OUR REF: 476088 - 01000

Roderick Lahey Architect Inc.
56 Beech Street
Ottawa, ON K1S 3J6

**Re: 929 Richmond Road Transportation Impact Assessment
Addendum #1**

SP-2

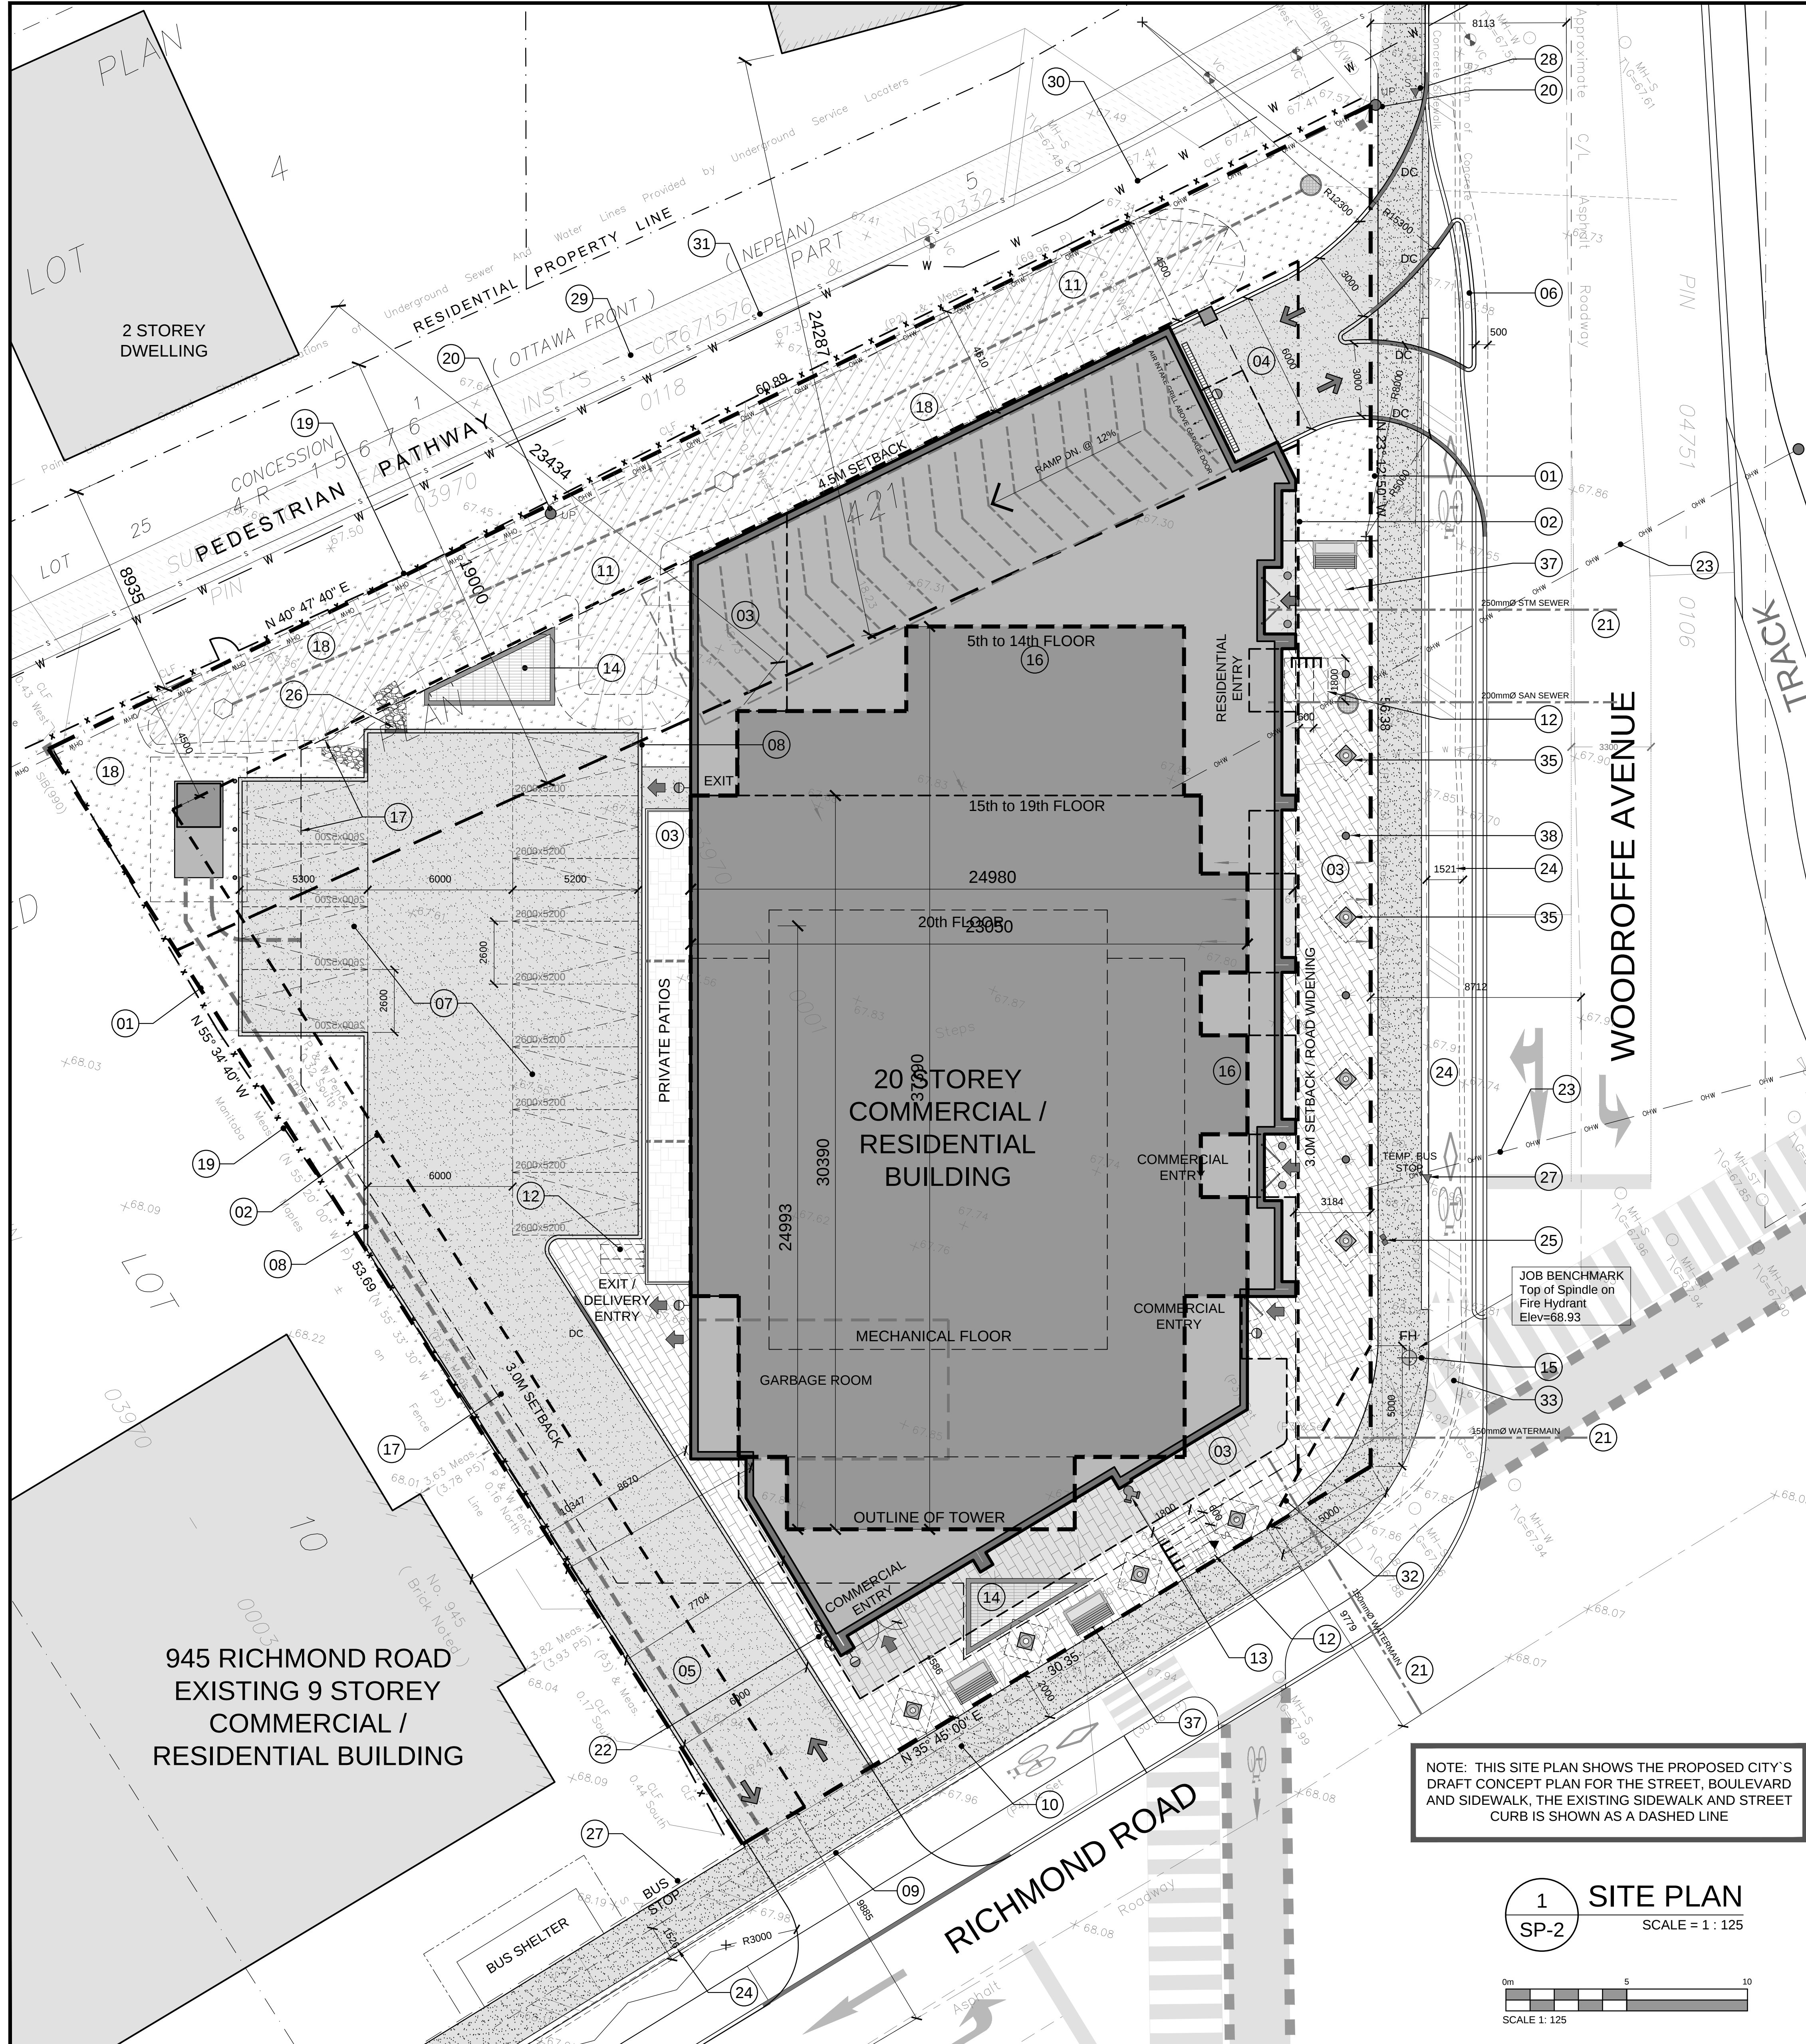
Comment 11: The access off Richmond Road is of particular concern especially since it is so close to the signalized intersection. Left turns into and out of this driveway for all vehicles should be prohibited. The option to signalize the driveway should not be considered. Inbound vehicles would likely have committed to turning into this access before having visibility of the signal thus becoming trapped. Moreover, having a signal would not eliminate blockages on Richmond Road because of vehicles wanting to enter. Option to use the area as a "truck court only" may be best solution if there is also space for trucks to turn around so they will not be backing out of the driveway to exit, (right out only).

Comment 19: *The full movement access on Richmond Road does not meet the minimum 6.7 m width.*

Response 11: The driveway has been revised to provide a 6 m wide drive aisle to accommodate 2-way vehicle traffic. As this proposed driveway provides access to only 12 parking spaces, the vehicle volumes are projected to be low. The driveway is located approximately 25 m from Woodroffe Avenue, which meets the City's Private Approach By-Law requirements, however it is located approximately 10 m from the eastbound STOP bar at the Richmond/Woodroffe intersection. There is also a westbound bus stop located immediately west of the driveway and buses will occasionally block the driveway for a short period of time. As such, it is recommended that left turns into and out of the driveway be prohibited through either signage, the construction of on-site channelization (i.e. pork-chop), or the construction of a median along Richmond Road. The most appropriate solution will need to be compatible with the City's planned complete street design for Richmond Road.

Response 19: The driveway width of the access to Richmond Road has been revised to 6 m, as shown on the attached Site Plan.
